Our Ref: A/85/26/NMA

Non material amendment following the granting of A/256/21/RES (as amended by A/88/24/S73) regarding play space.

Land North of Water Lane Angmering

SHEET TITLE: **Nature Playscape Proposal**

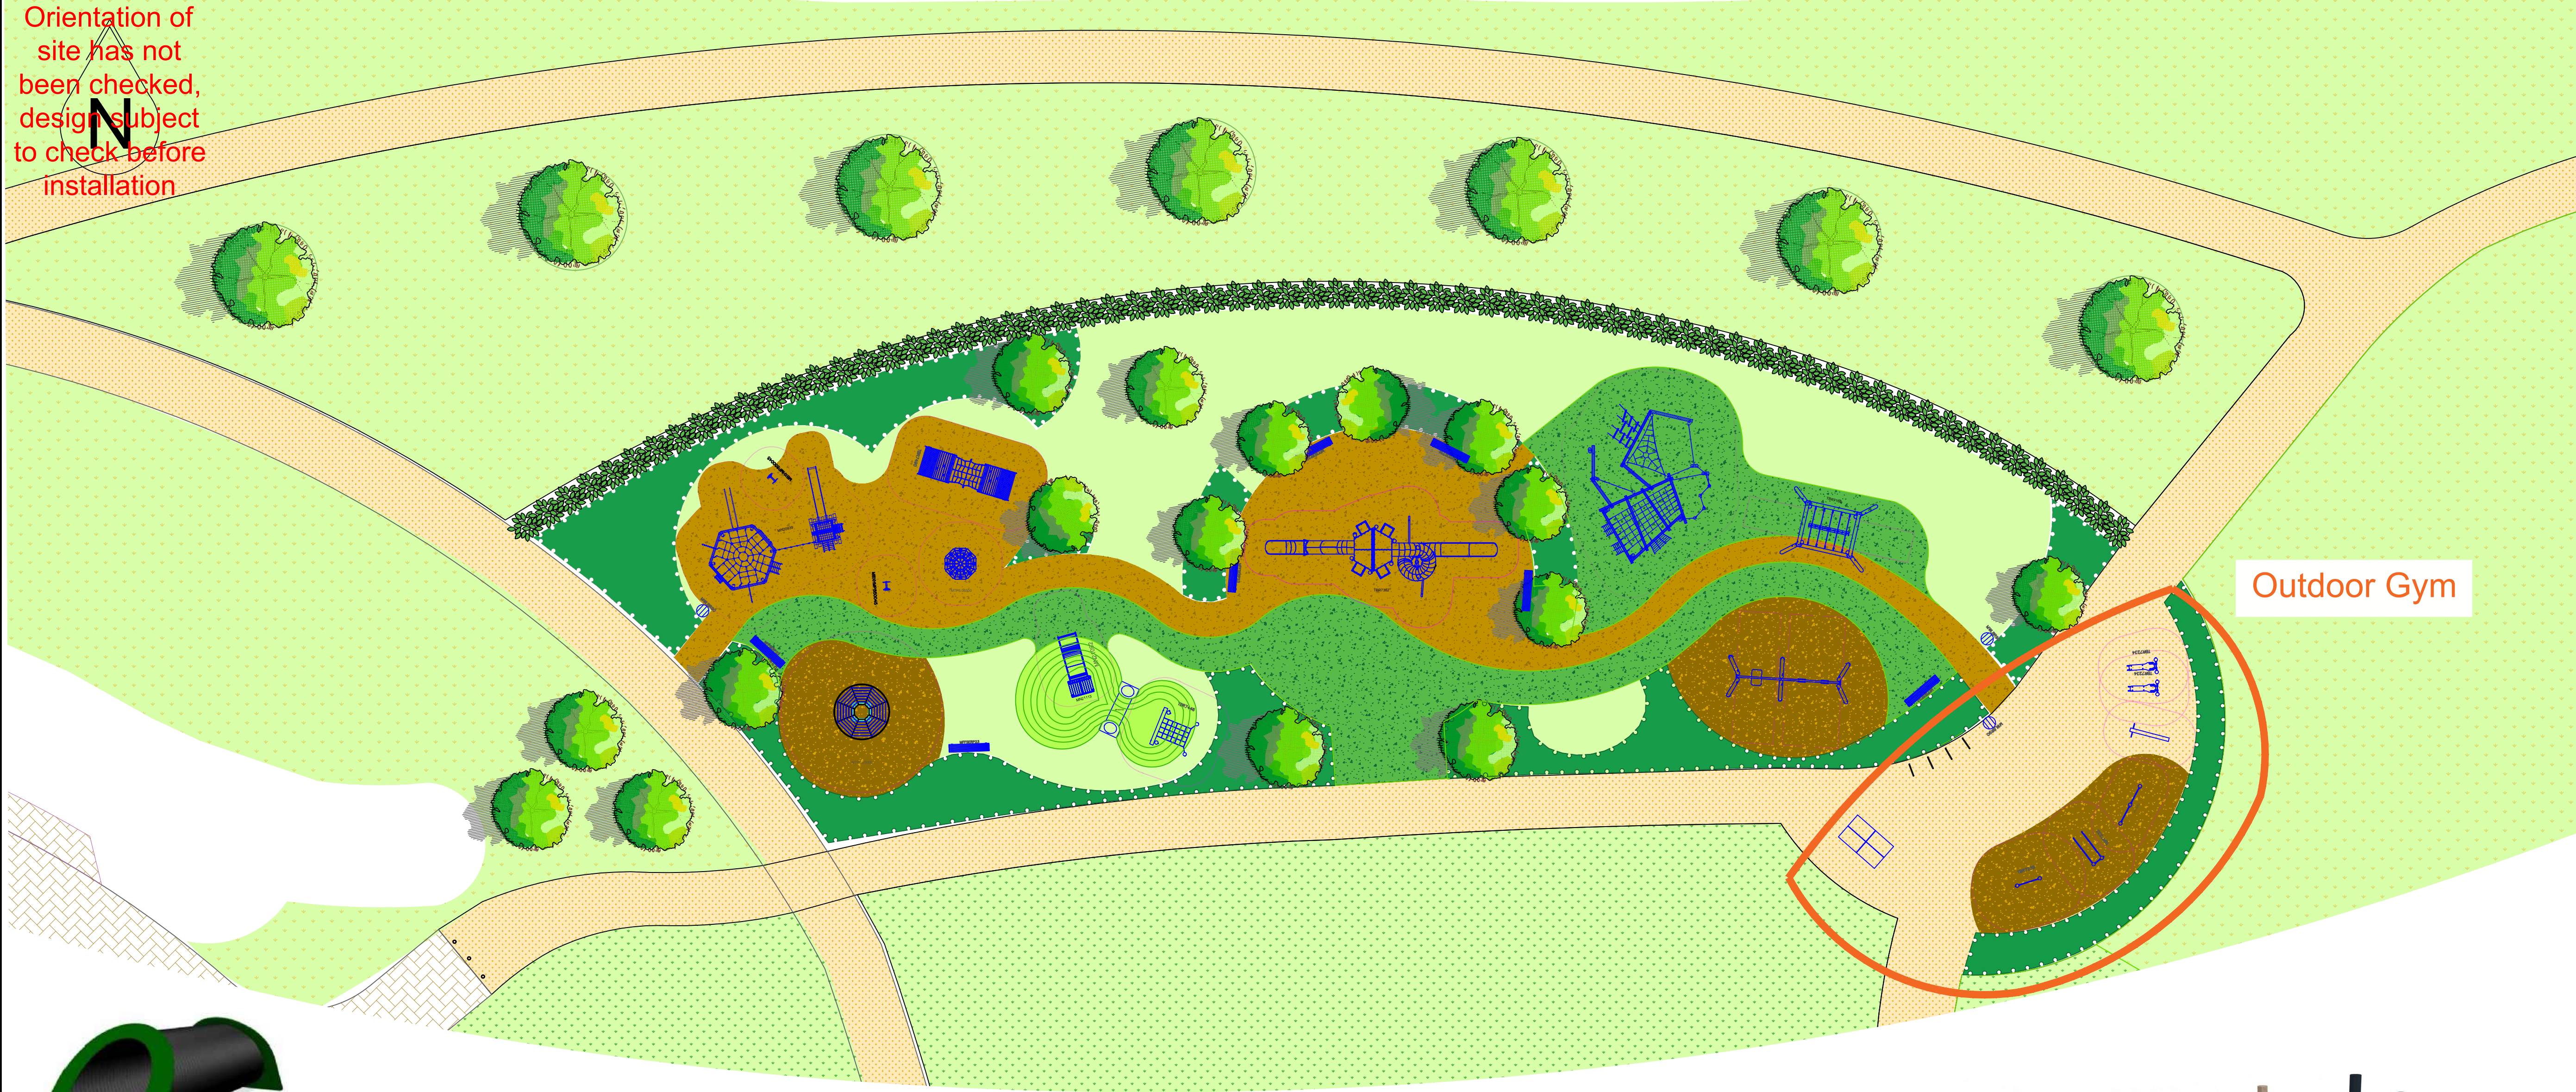
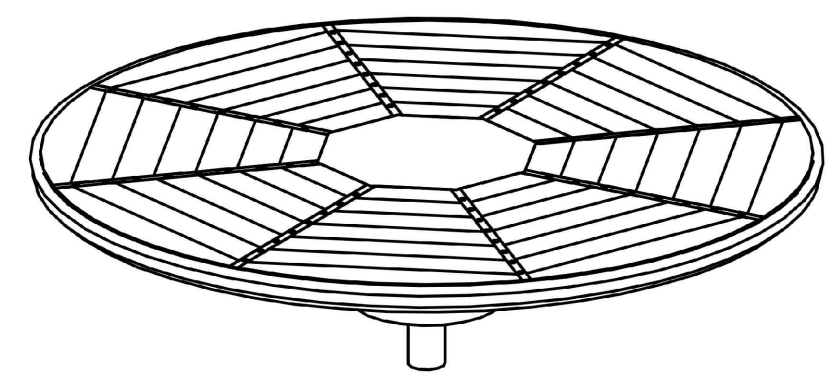
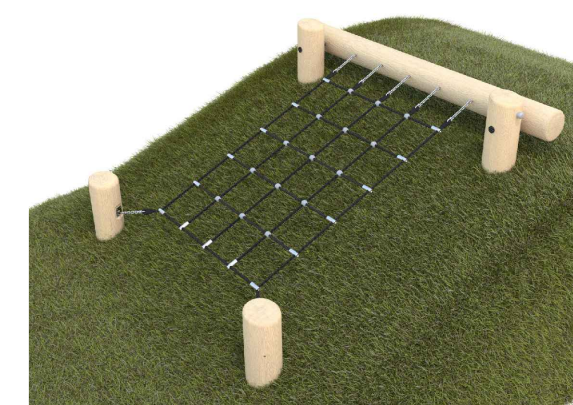
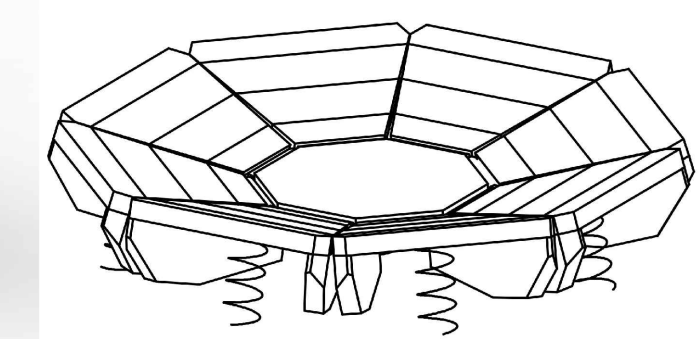
The proposed Miracle Design & Play specification equipment which would include a conventional play tower, an enclosed slide, scaled down swings, standard multi-play equipment and standard manufactured playground items which would be smaller in scale to those originally proposed. However, the proposed changes in equipment would fundamentally alter the character of the approved nature playscape from a landscape-led nature play experience to a conventional equipped playground; resulting in a material change in impact and experience on the intended users of the play area from the equipment in the approved scheme.

The proposed changes would be a material change from the approved Nature Playscape under A/256/21/RES and therefore be unacceptable under section 96A of the Town and Country Planning Act 1990.

The proposed changes in specification of equipment for the Nature Playspace would fundamentally alter the character of the approved nature playscape from a landscape-led nature play experience to a conventional equipped playground. This would be a material change in impact and experience on the intended users of this play area and would therefore not be allowed under section 96A of the Town and Country Planning Act 1990. As such, the application is refused for the reasons set out above.
